Application No: M/91/21/PL
Site Address: 27 Central Drive Middleton-On-Sea PO22 7TT
Description of works: Variation of condition 2-approved plans & removal of condition 4-materials included on plans imposed under M/25/19/PL.

Thank you for your internet representation made on 13th July 2021 which has been recorded as an objection with the comments as follows:

Reference M/91/21/PL
27 Central Drive Middleton-On-Sea PO22 7TT

PROJECT	27 Central Drive - Elmer Beach	DATE	16/09/18
TITLE	Proposed South Elevation	DRG NO	IBA/507/05
SCALE	1 : 50	REVISIONS	B

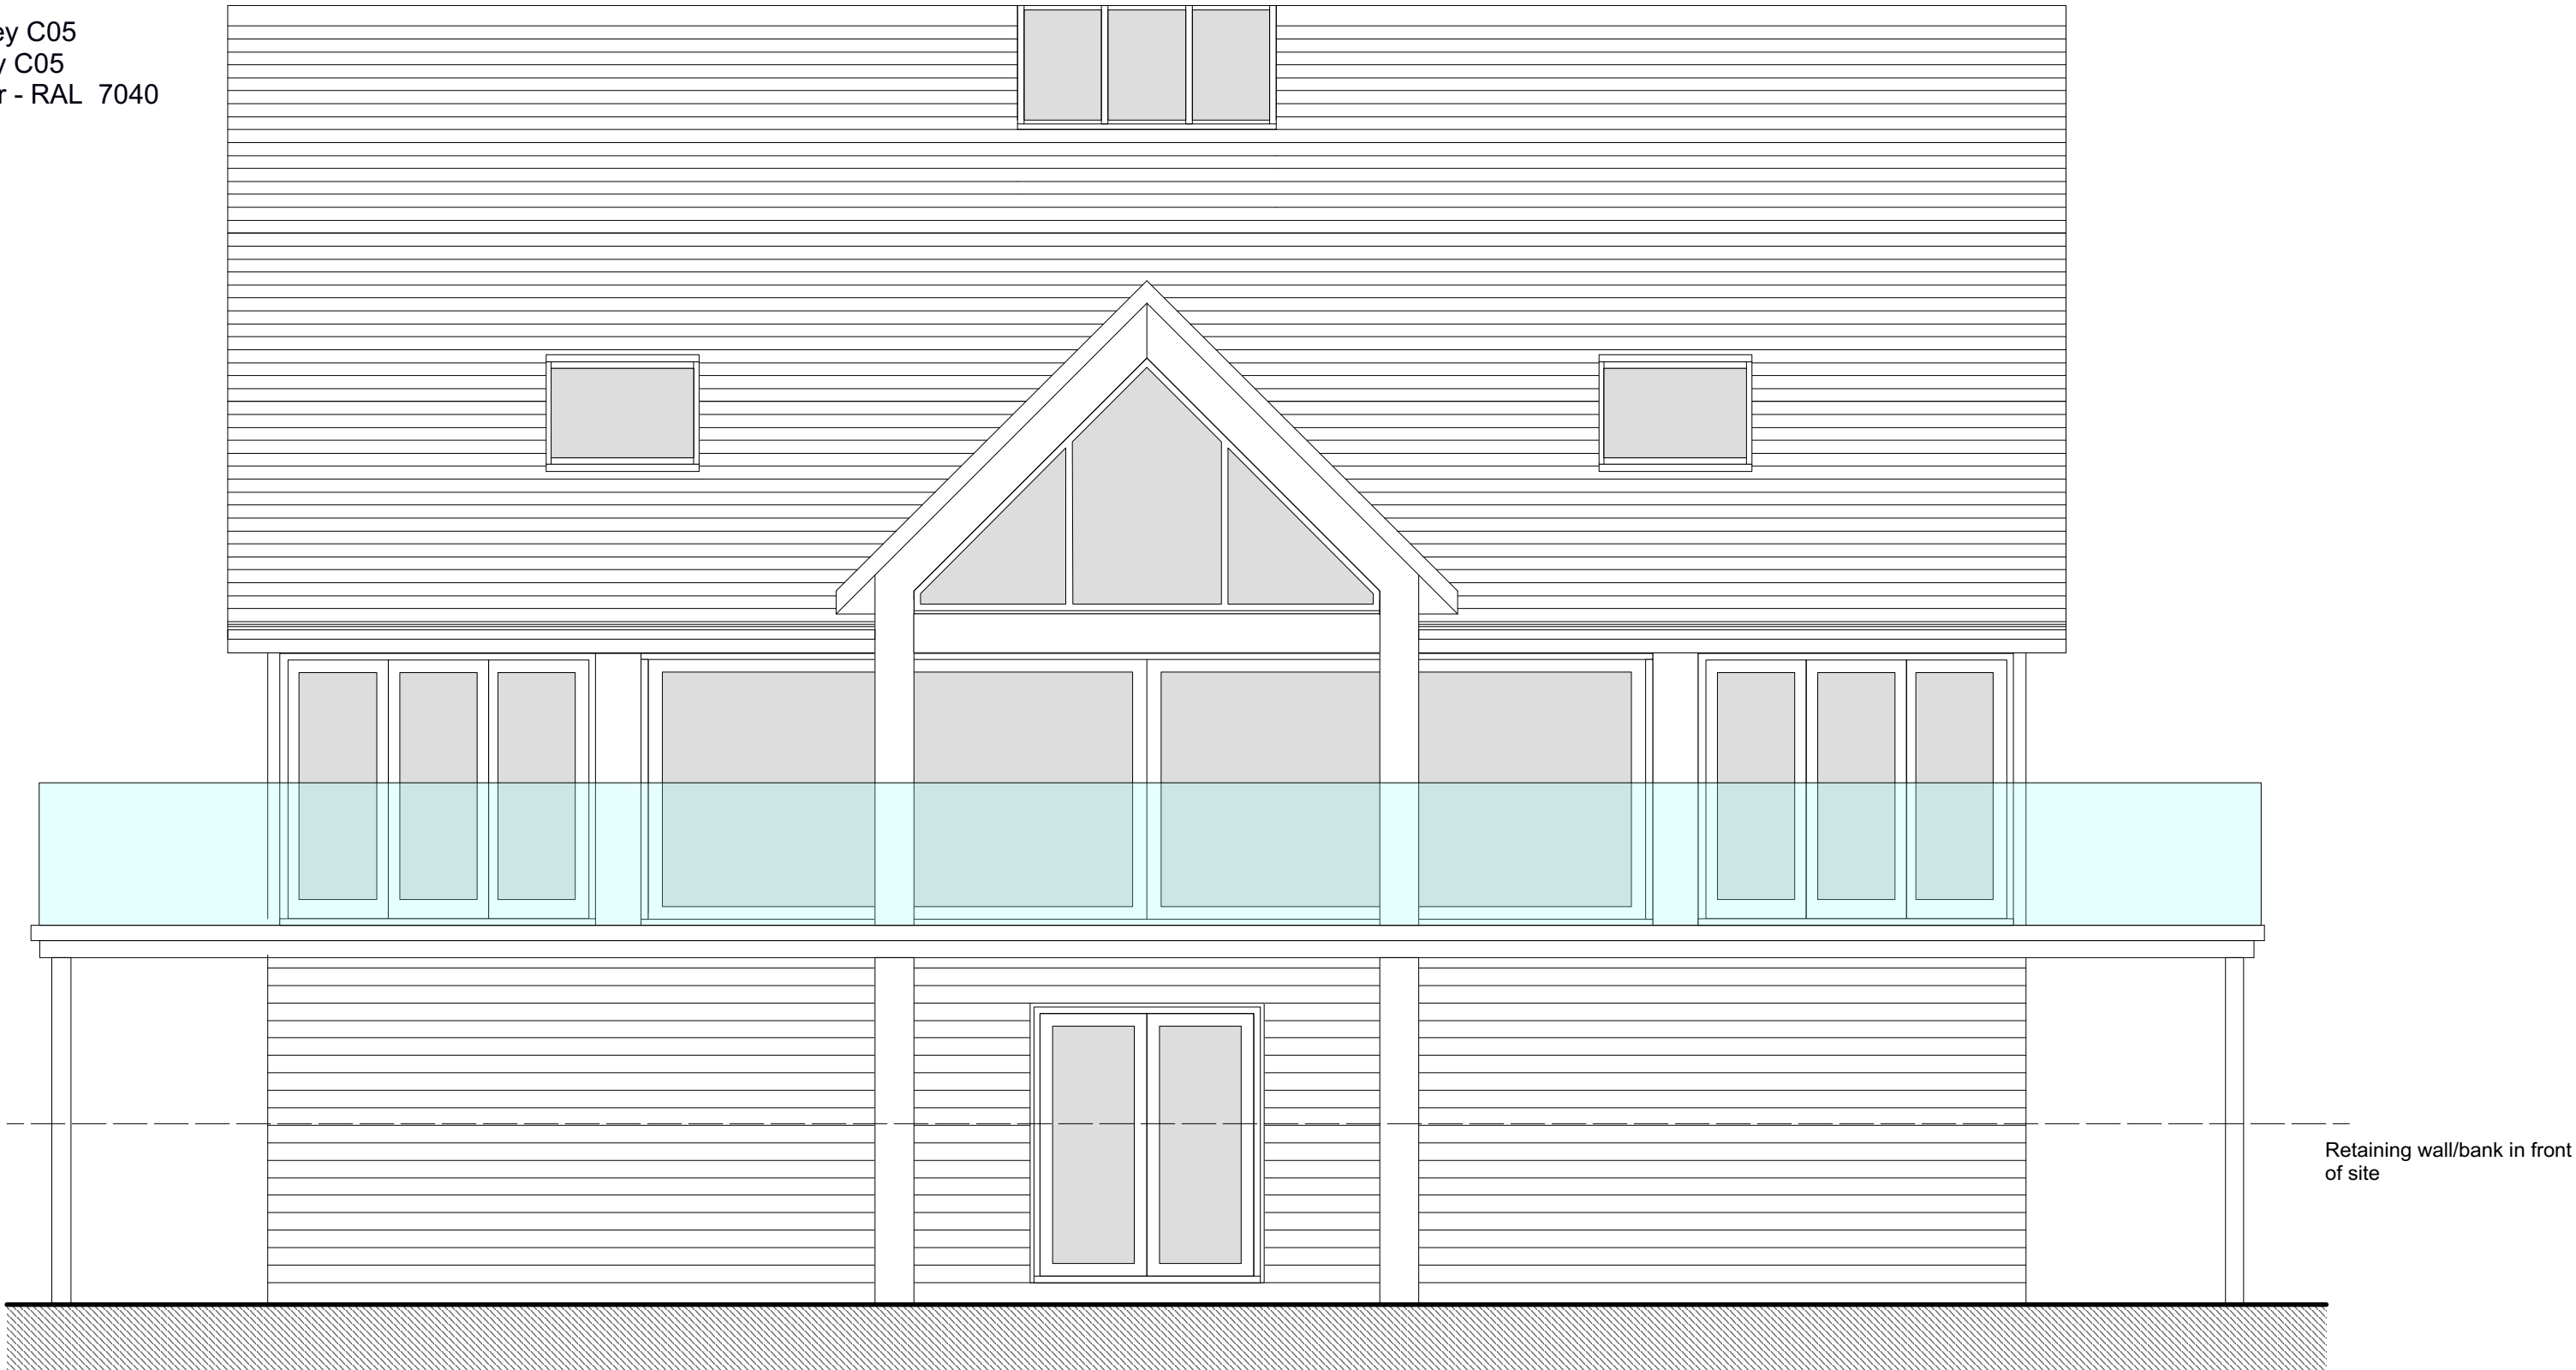
I object to the revised planning application on the grounds that it seeks retro permission to build to an excessive height which was previously disguised by the plans previously filed and Conditionally Approved. See M/25/19/PL 'Proposed South Elevation IBA/507/05 Rev A'. These plans clearly showed the roofline of the neighbouring property 25 Central Drive as only slightly below the planned roofline of 27 Central Drive. As both properties are owned by the developer there can be no excuse that the architect did not have access to 25 Central Drive for measuring purposes.

Even ADC's planners appear to have been misled, not just neighbours who do not have surveying skills or equipment or access to the properties for measuring purposes. The plans are all that neighbours had on which to judge building height. It is only now that the roofline is being built that the full consequence of the misleading plans has become glaringly obvious. Even to the unskilled eye there is gross discrepancy on the roof height of 27 over 25 as shown by the original plans.

I object to the revised proposals and request that the new building height conforms to the original conditionally approved plans. If the attempted excess height is retro-sanctioned it calls into question the whole working practice of ADC Planning.
